RESPONSES TO LOI COMMENTS

File Number PPR2411, Parcel 5308000074

June 11, 2024

# 7280 NEVADA LANE

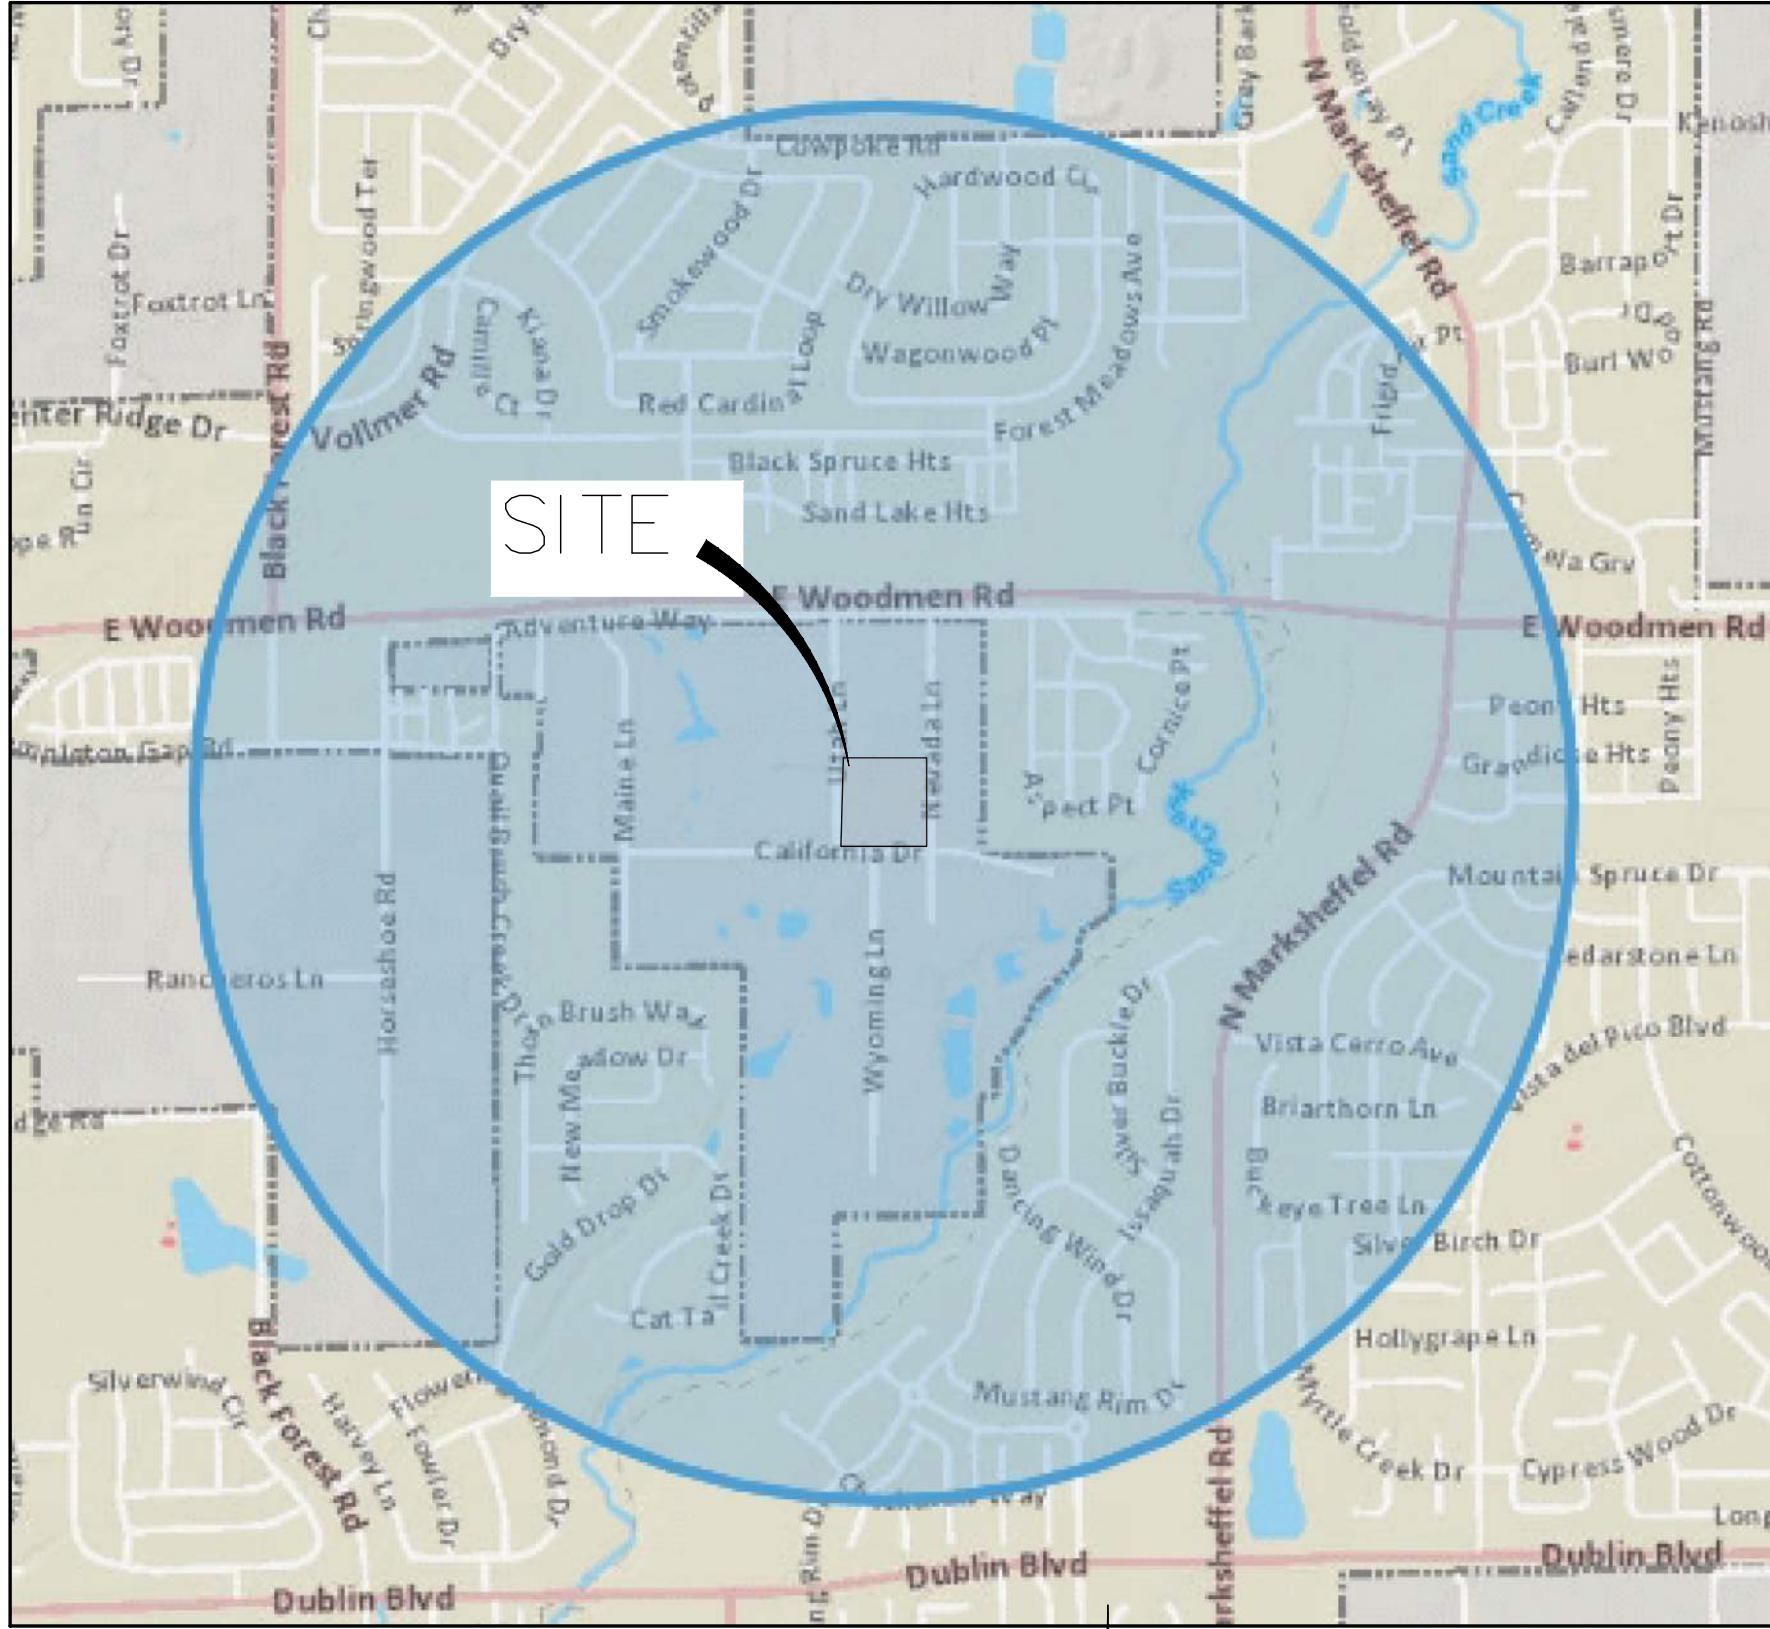
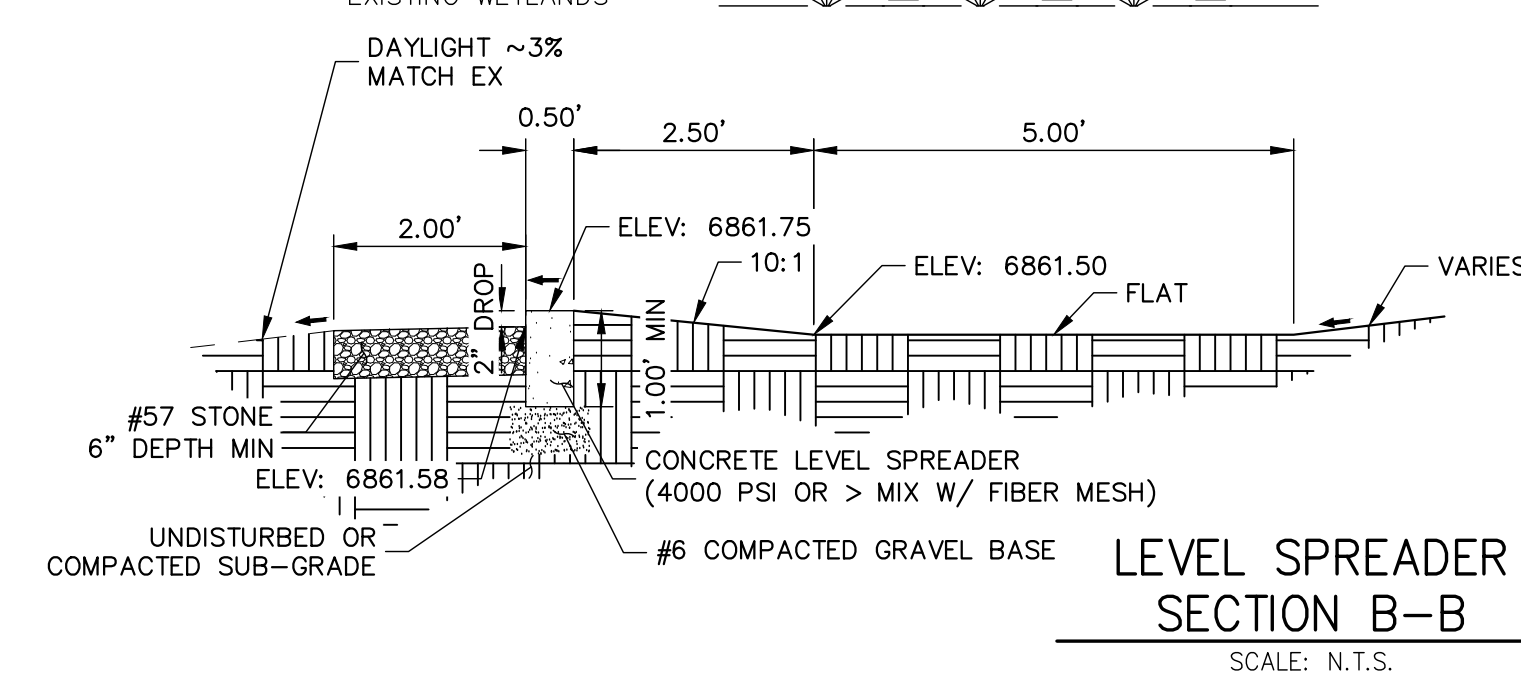
Please provide a brief discussion about the site's drainage and grading. Will it have adversely impact adjacent properties or stormwater runoff. if not, please state.

The county has determined that even though there is not any new construction planned on the site, the amount of disturbed area on our parcel has triggered the need for a stormwater detention pond engineered to release stormwater at or below historic rates for the location. Our civil engineer Olliver Watts PE has had several meetings with Hao Vo, PE and Glenn Reese PE from the El Paso County Stormwater Department to put together an appropriate grading and drainage design for our site. Our Drainage Report has been updated now with a stormwater detention pond. The grading on the property of site will drain toward the pond with the exceptions of the septic field area and Southeast corner of the parcel which do not have a special drainage requirements per EPC Stormwater. The pond will be maintained in accordance with the O&M Manual provided by the design engineer. The installation of the detention pond/grading system and responsible on-going system maintenance will ensure that adjacent properties and other sites downstream are protected from the negative effects of stormwater such as erosion, water quality, etc.
